Re: MMC Congress Building | 22 Bramhall St | Level III Site Plan
Response to City Reviewer Comments 2

Comments from City of Portland Traffic Consultant – Tom Errico, TY Lin Dated November 9, 2018

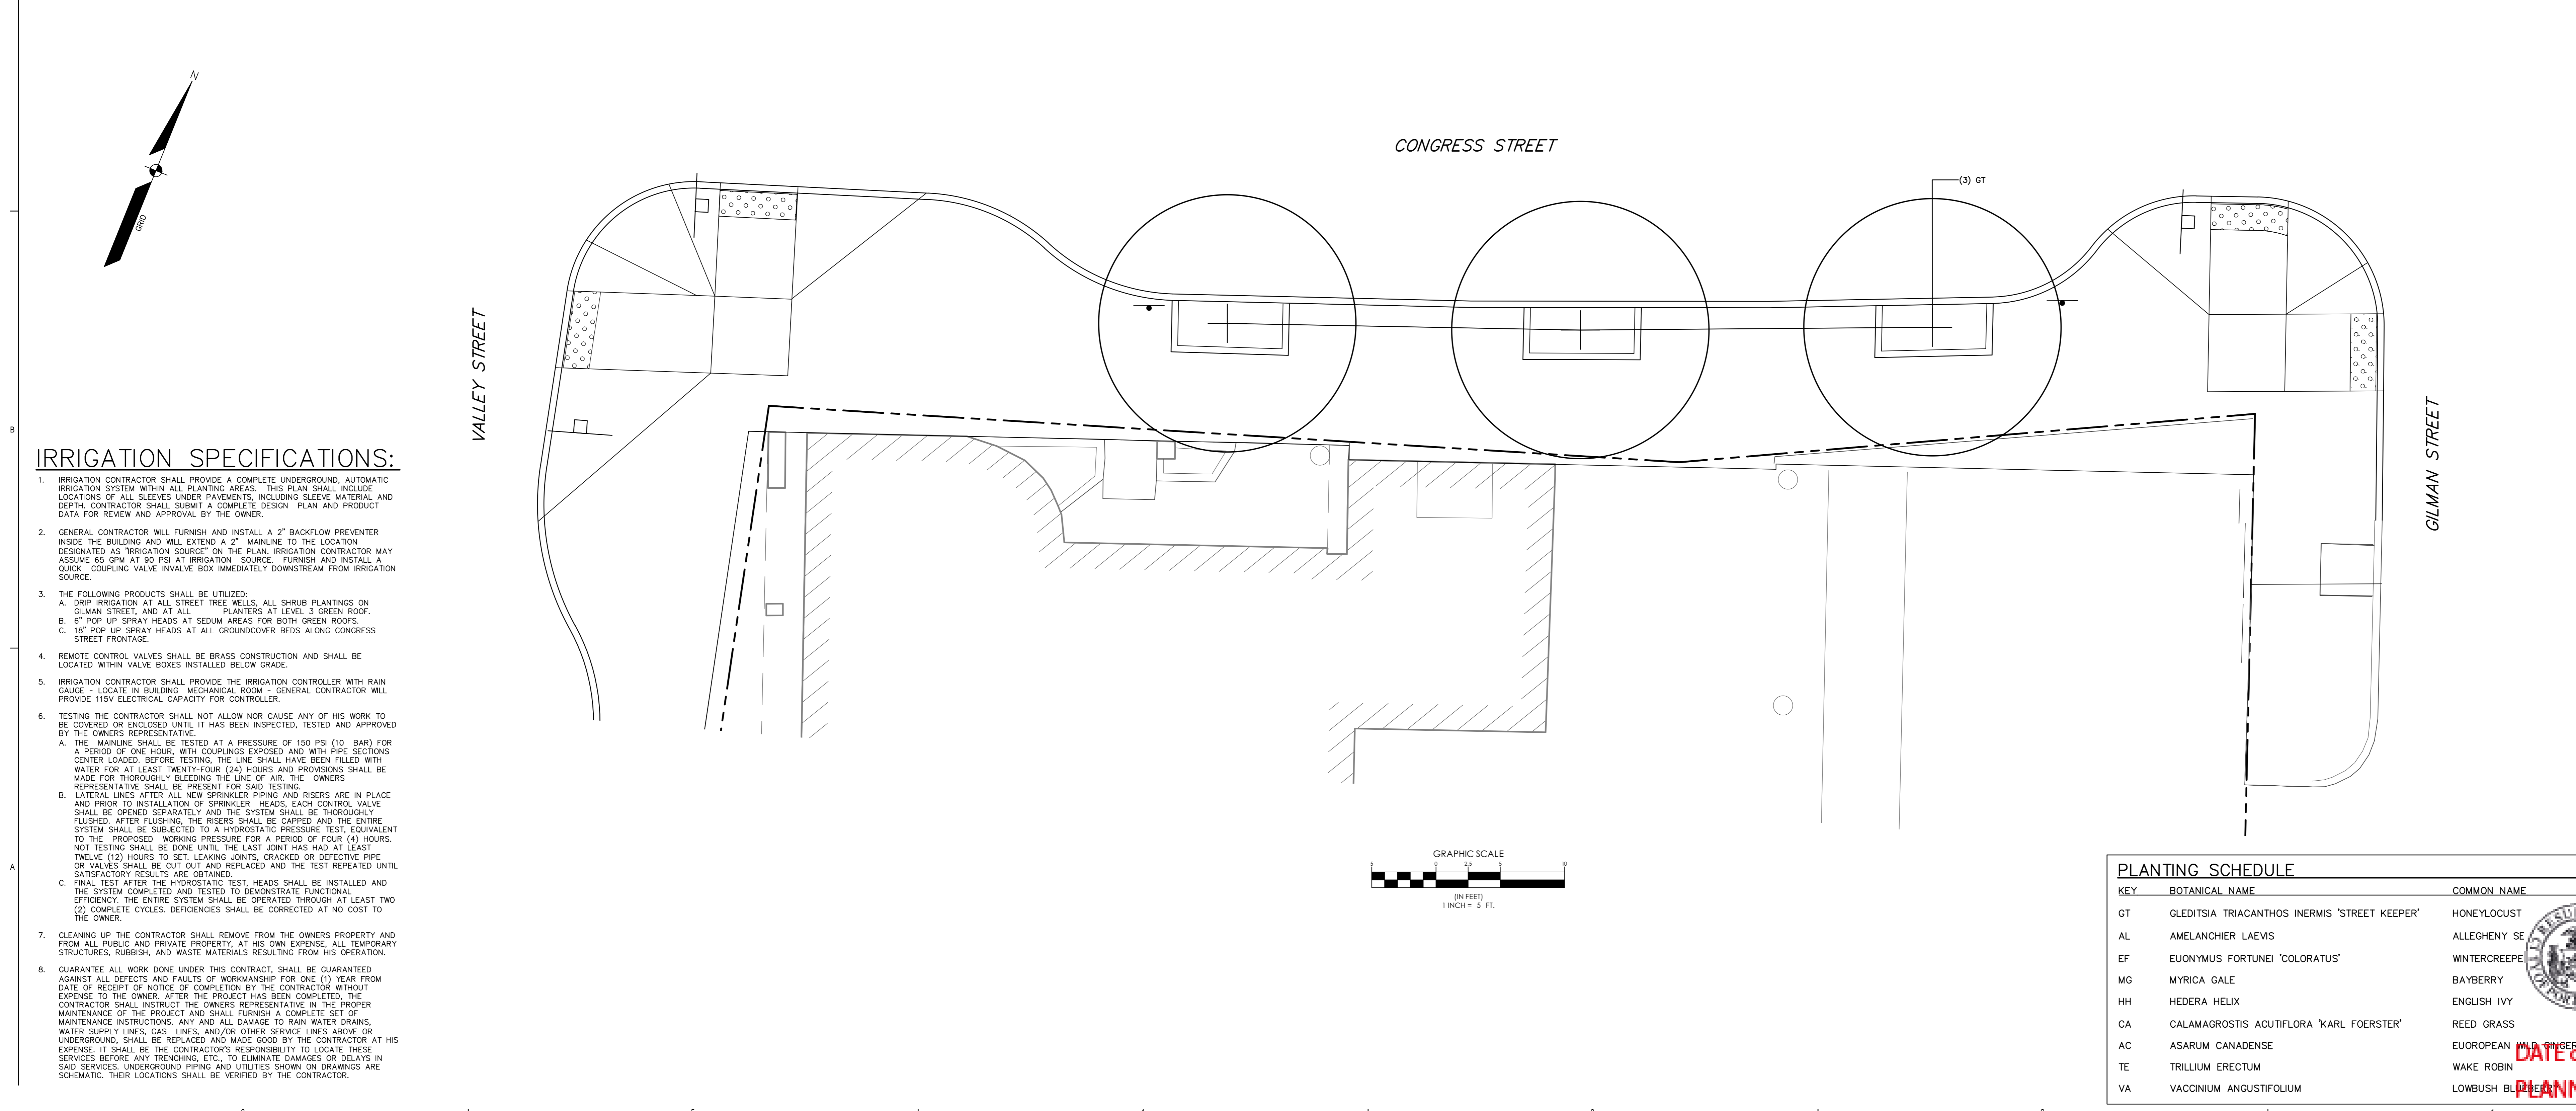
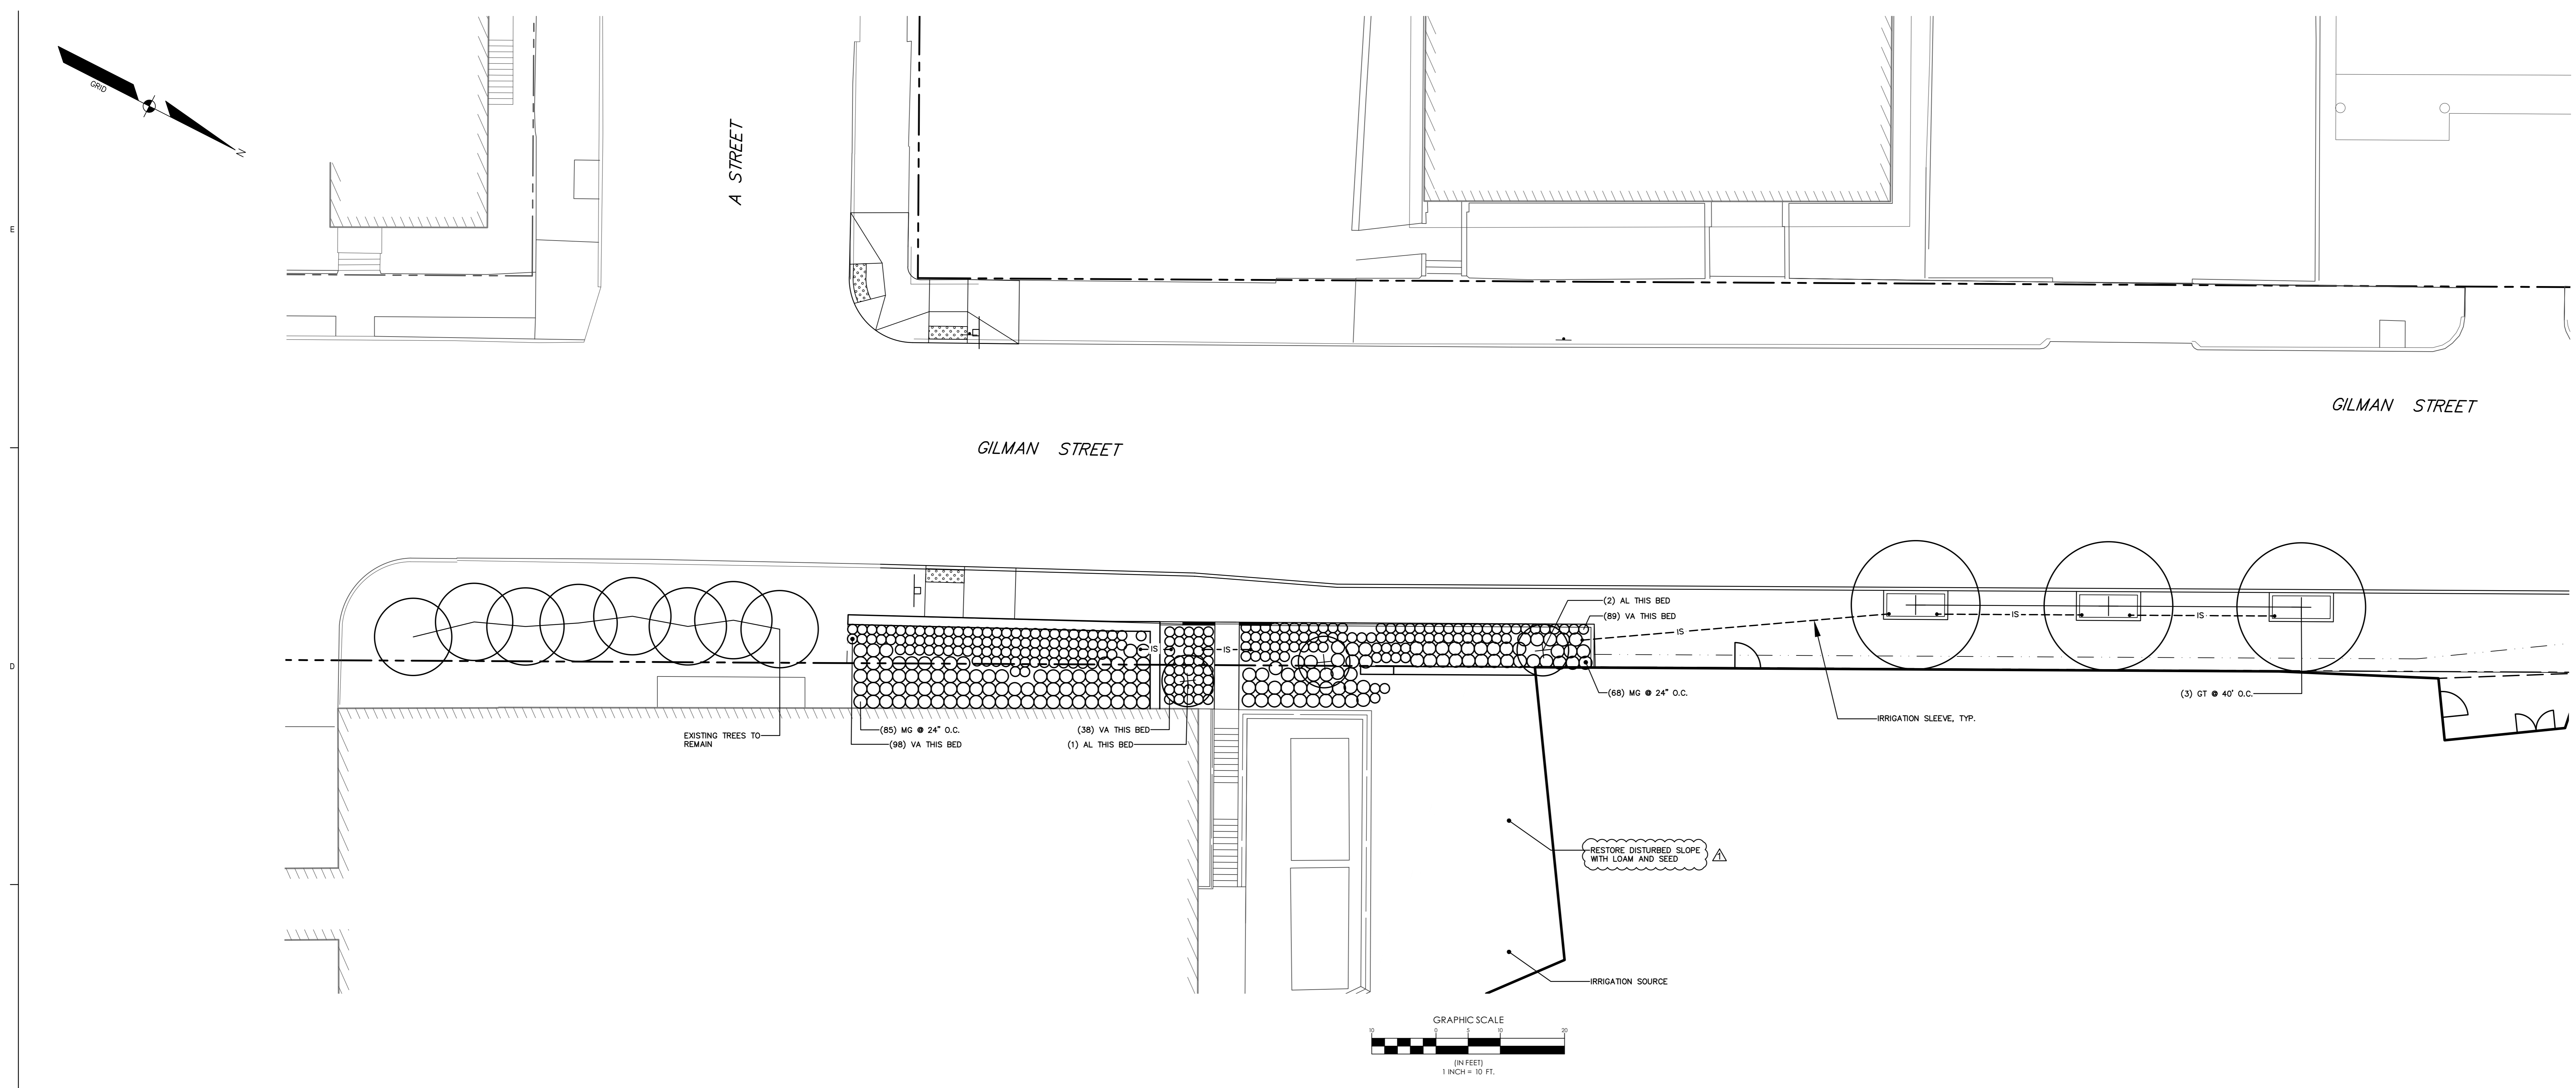
23. Street trees - knowing that the project frontage will have a bus stop and bring in a tall vehicle close to the curb, a more upright cultivar of Honeylocust like the 'Streetkeeper' might be a good selection. 'Princeton' or 'Accolade' Elm could work as well. The web links below offer some comparison values on the attributes that can help select what works best for this site. (Open to other suggestions also)
- o <http://www.jfschmidt.com/introductions/streetkeeper>
 - o <http://www.mortonarb.org/trees-plants/tree-plant-descriptions/accolade%E2%84%A2-elm>
 - o <http://www.mortonarb.org/trees-plants/tree-plant-descriptions/princeton-elm>
 - o <http://www.jfschmidt.com/introductions/streetkeeper>
 - o <http://www.streetkeeper.net>

Response: The street trees on Congress Street will be specified as 'Streetkeeper' Honeylocust.
